# KITTITAS COUNTY COMMUNITY DEVELOPMENT SERVICES

**RE: Horish SEPA Checklist (SE-24-00013) – Deemed Incomplete**

Parcel #'s: 546534 & 516534

**RE: Horish SEPA Checklist (SE-24-00013) – Deemed Incomplete dated March 29,2024**

GRADING PLAN AND STORMWATER MANAGEMENT

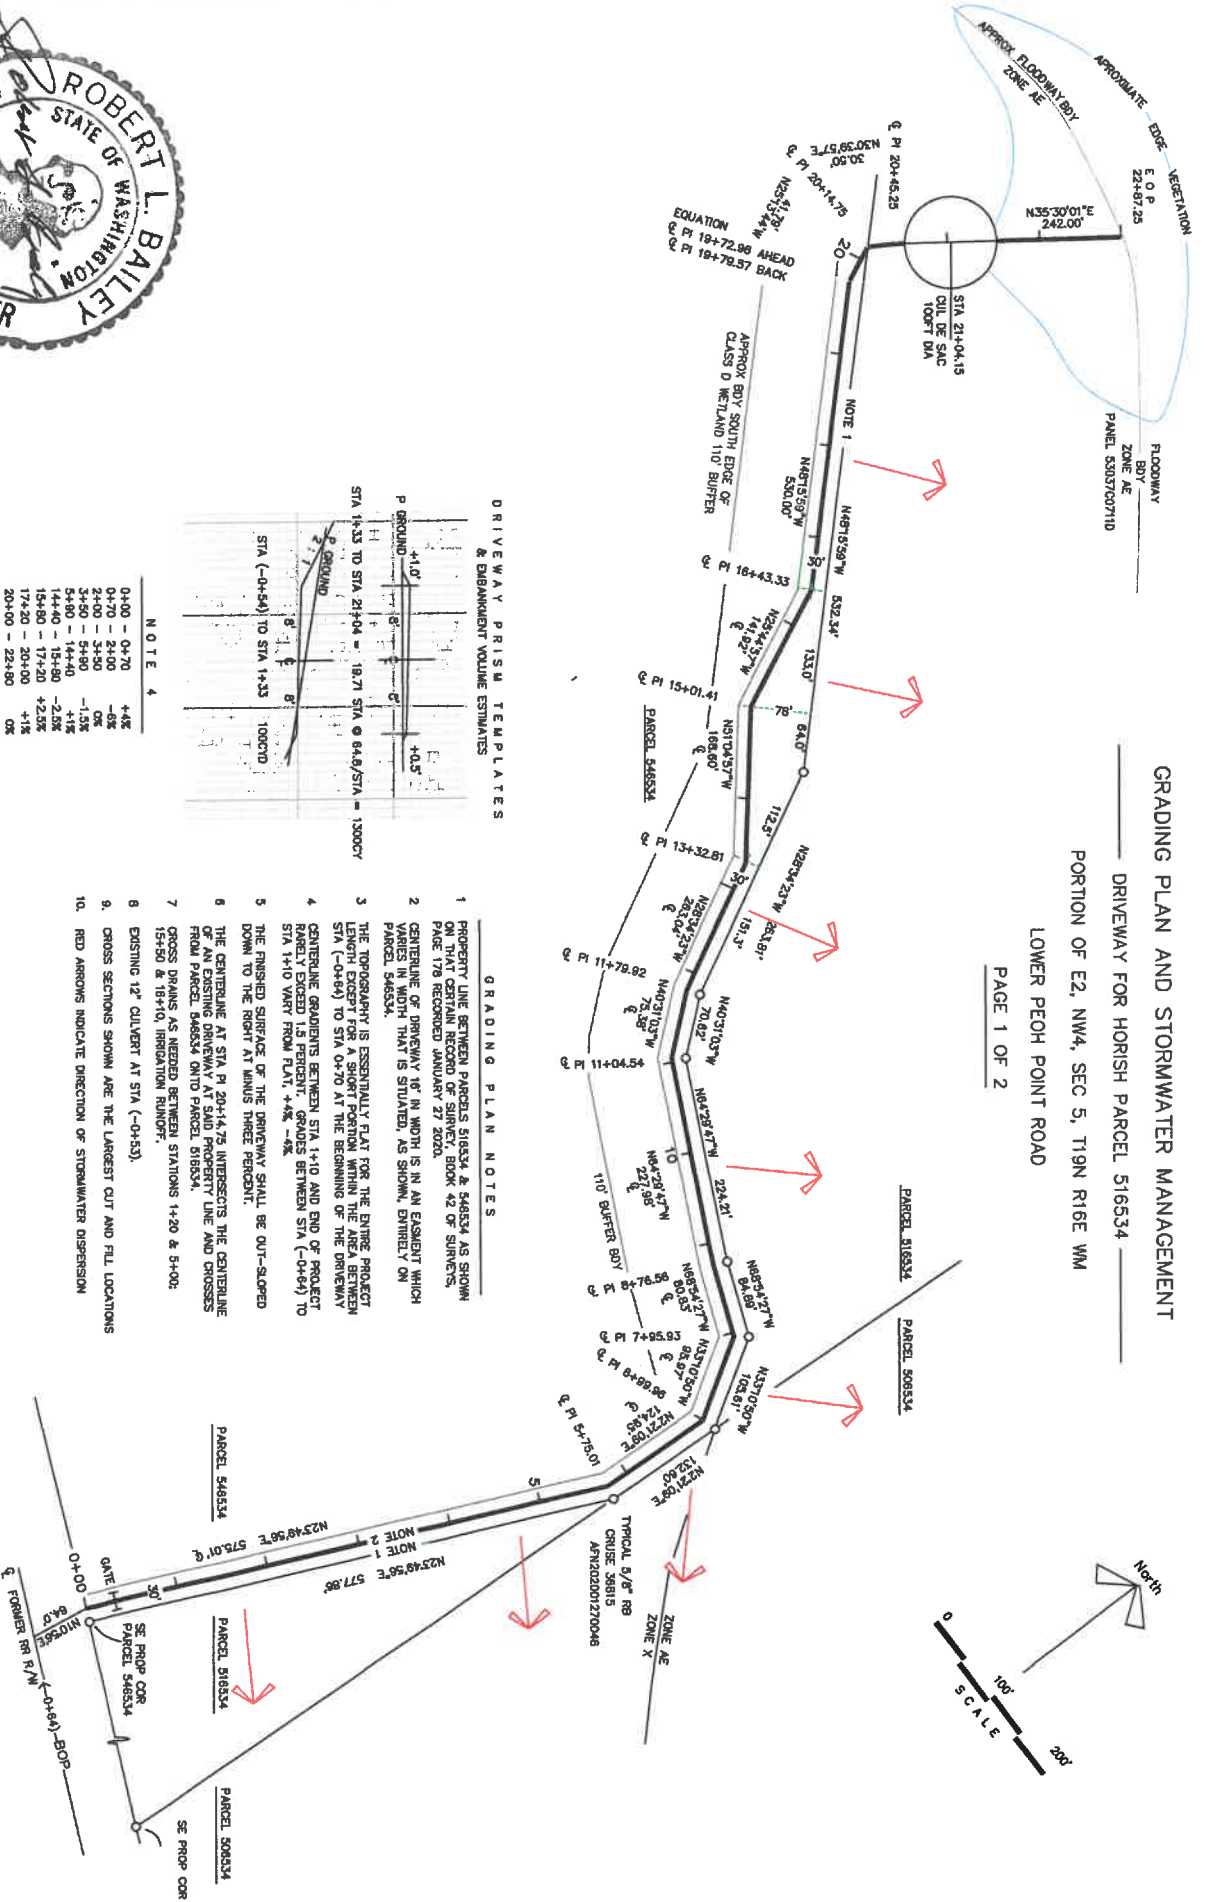
1. SEPA checklist item B2(a) asks "What types of emissions to the air would result from the proposal during construction, operation, and maintenance when the project is completed? If any, generally describe and give approximate quantities if known." This question was provided a "none" response. Please update this item to speak to any construction equipment exhaust or dust created by any dirt work & application of gravel driveway surface.

2. SEPA Checklist Item B3(a) asks about water bodies on or in the near vicinity which was answered "No". Based on the critical areas report submitted for this site, this is not true. Please update Section B3a, questions 1, 2 and 3 to reflect more accurate & appropriate answers.

3. SEPA Checklist Item B3(c) asks about stormwater runoff. The answers for questions 1 & 3 are not adequate (1. None, 3. No) Please update Section B3c, questions 1 & 3 to reflect more accurate & appropriate answers.

Emission type: diesel – CO2, Estimate 9 tons during construction; maintenance of driveway post construction, estimate 0.5ton/year. Dust abatement as needed during construction, water wagon; post construction, annual application of lignin.

Yes, 2. A. Unnamed seasonal waterway, volume varies with the seasons and beaver dams. Flows southeasterly into the Yakima River. B. Unnamed pond. Flows southeasterly into another unnamed pond.

Between Stations (Sta) 8+00 to Sta 9+50, a distance of 150', is adjacent to said unnamed waterway. Furthest distance from driveway to said waterway: 53', N20°E; closest distance from said waterway, 30', N20°E. Elevation difference from driveway to water surface, -18'. Between Sta 5+25 to 5+75, a distance of 50', the said unnamed pond 30' distance and approximately 8' lower then the driveway.

Between Sta 8+00 to Sta 20+00, a distance of 1200', the driveway is situated on pasture land southerly of tailwater runoff from irrigation water, in the buffer of a Class D wetland. Estimate 800cy of fill material to construct the driveway in said buffer. Source of fill material: Owner's existing stockpile of material on her adjacent property parcel 506534.

Source of runoff: rainfall and tailwater; collected with ditch adjacent to driveway. Flow, if any, will be southeasterly into the pond in vicinity of Sta 5+25 – 5+75; and into a portion of said unnamed seasonal waterway in the vicinity of Sta 8+00 – 9+50

The construction of the driveway does not adversely affect the existing drainage pattern on the pasture. Cross drains will be utilized where required to facilitate drainage issues.
